Application number: 2026/91048	
What is the application for?:	Erection of single storey front extension
Address of the site or building:	6, Lee Court, Lee Street, Littletown, Liversedge, WF15 6QT
Postcode:	WF15 6QT

We object to planning permission being granted for application 2026/62/91048/E “Erection of single storey front extension” at 6 Lee Court WF15 6QT on the grounds below.

PROPOSED

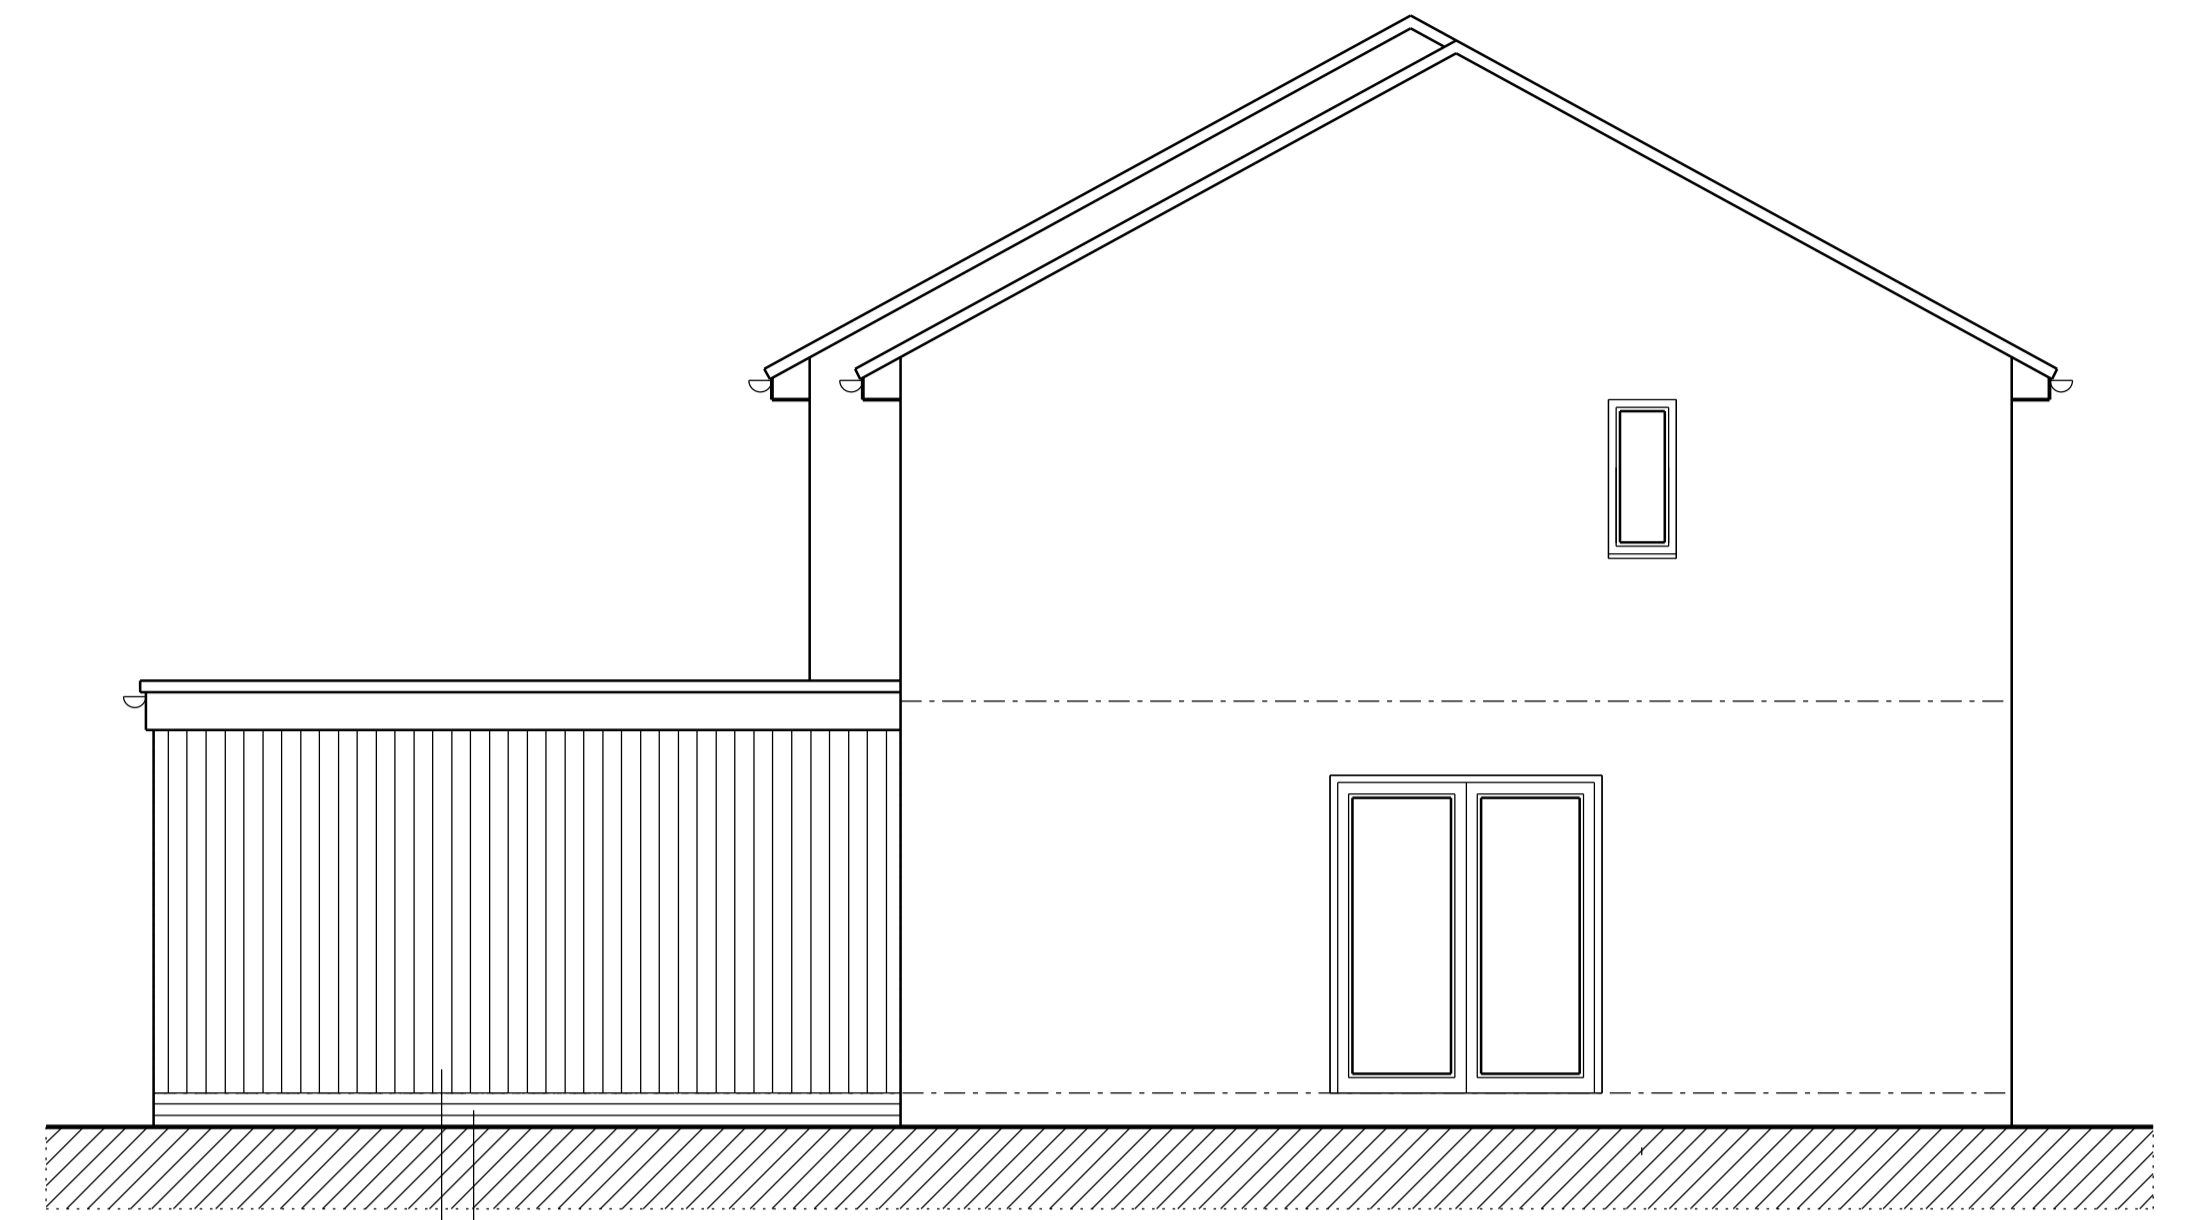
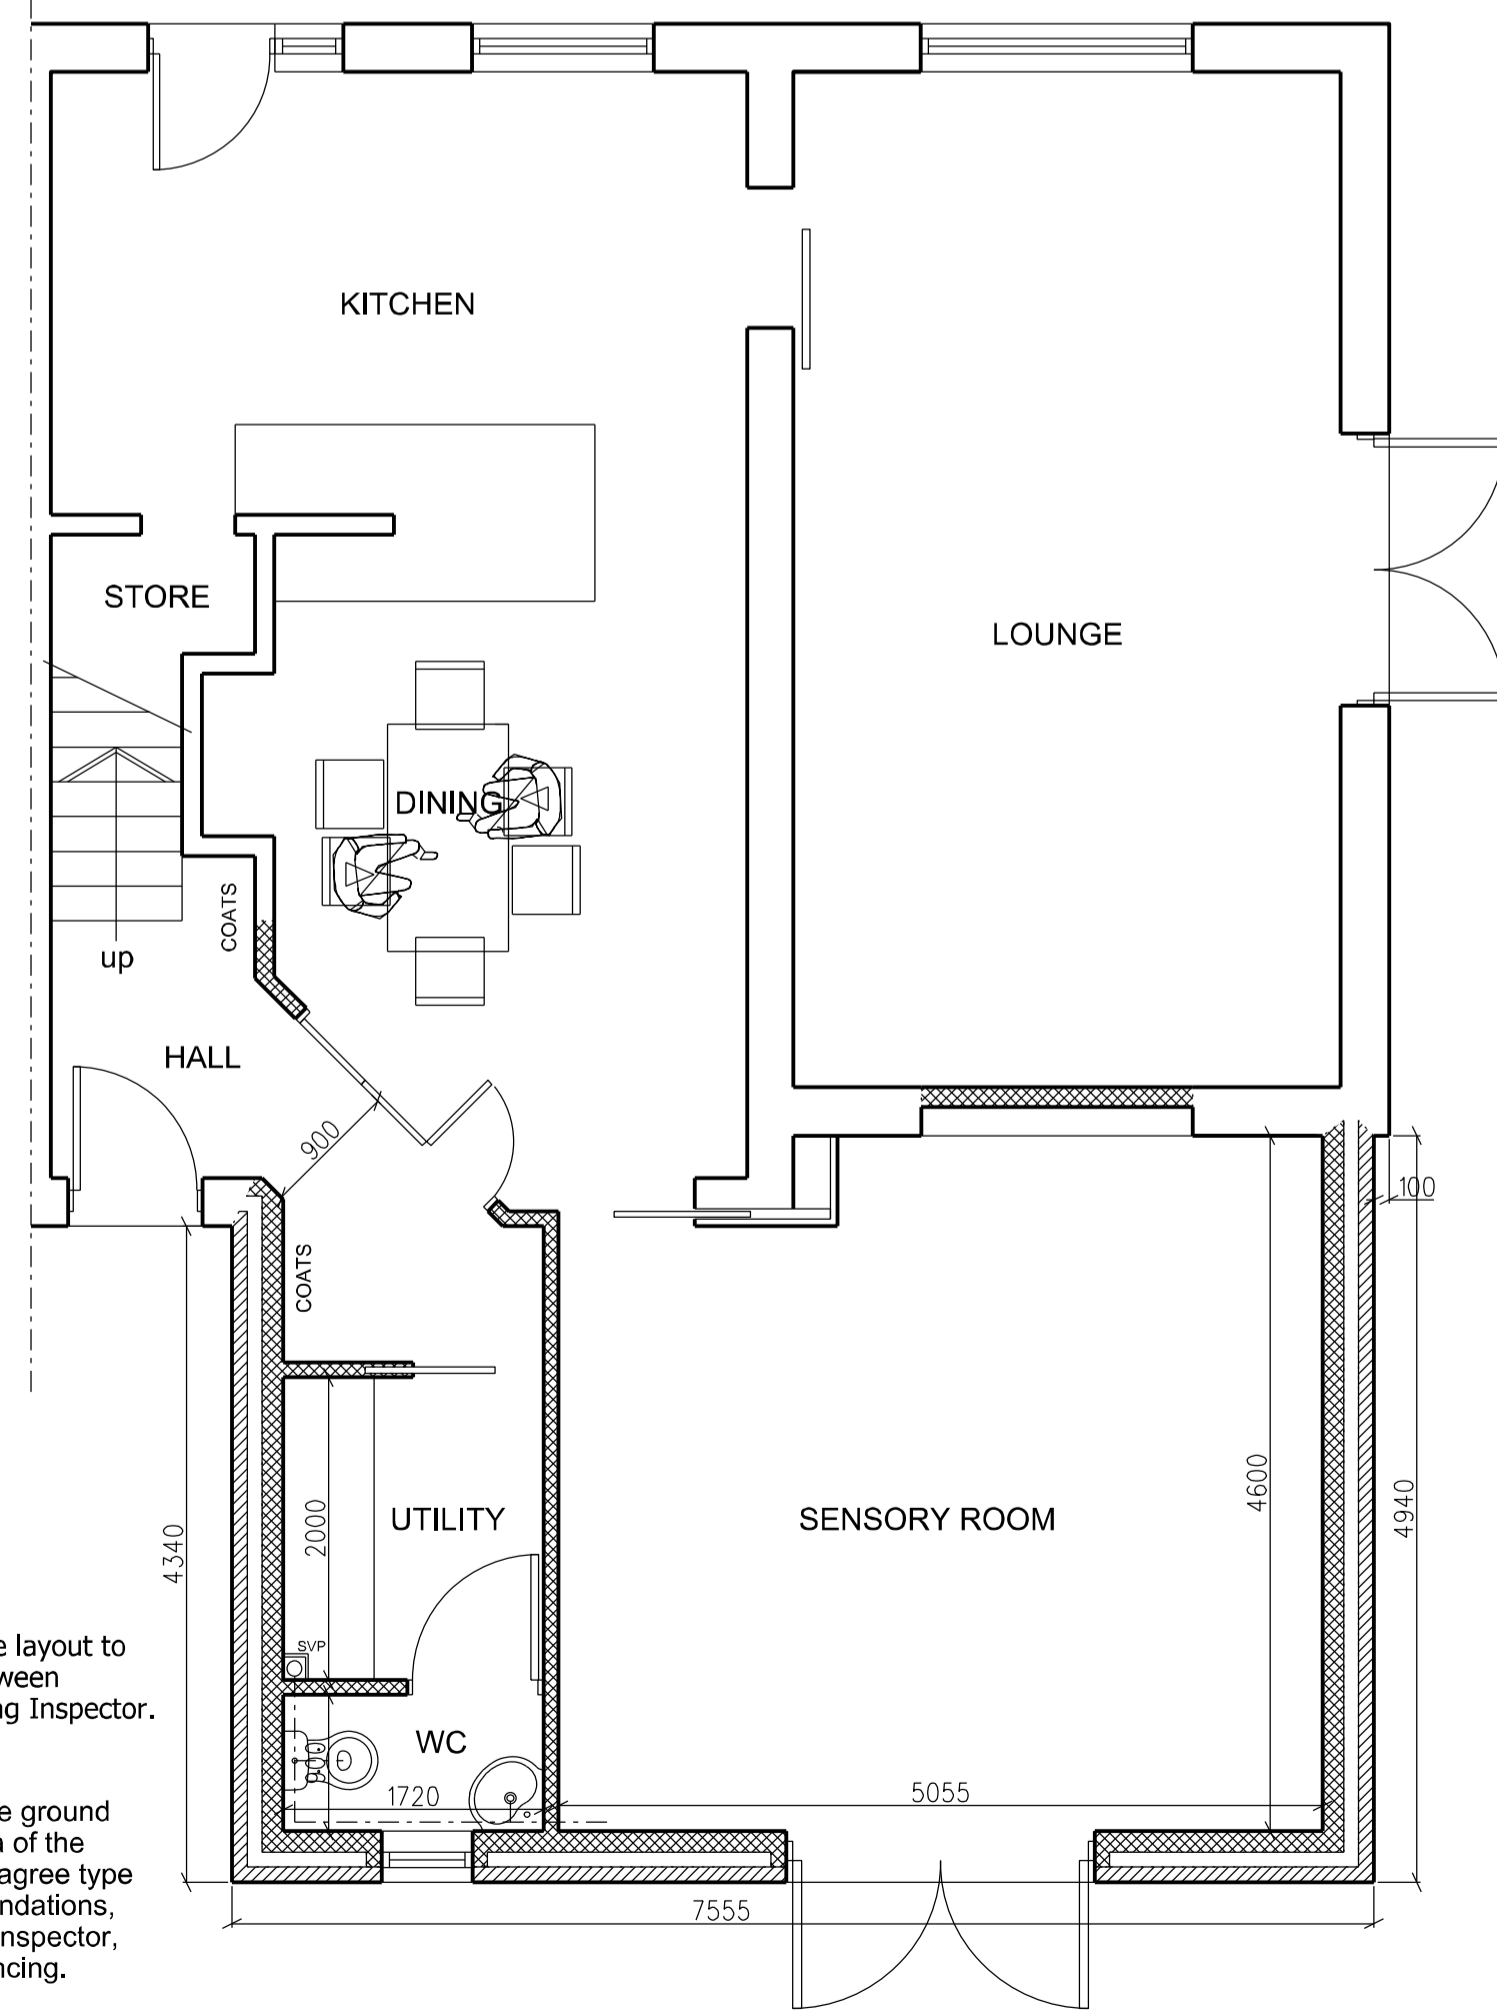
- Is not in keeping with the appearance, design and local character of the street scene.
- Extends forward of the existing street building line.
- Will adversely affect the amount of natural light enjoyed by the adjoining property and unduly reduce the outlook of the neighbouring properties.
- Through its size is not subservient to the original building, harms the character of the house and surrounding area and does not match the existing materials and design of the original and adjoined properties.
- Severely reduces the amenity of the adjoining properties as all of the adjoined properties in Lee Court derive a great deal of amenity and appeal from the open plan aspect of the front gardens and shared space and uniform design and building materials.

The proposed extension to the front of the property would breach these restrictive covenants
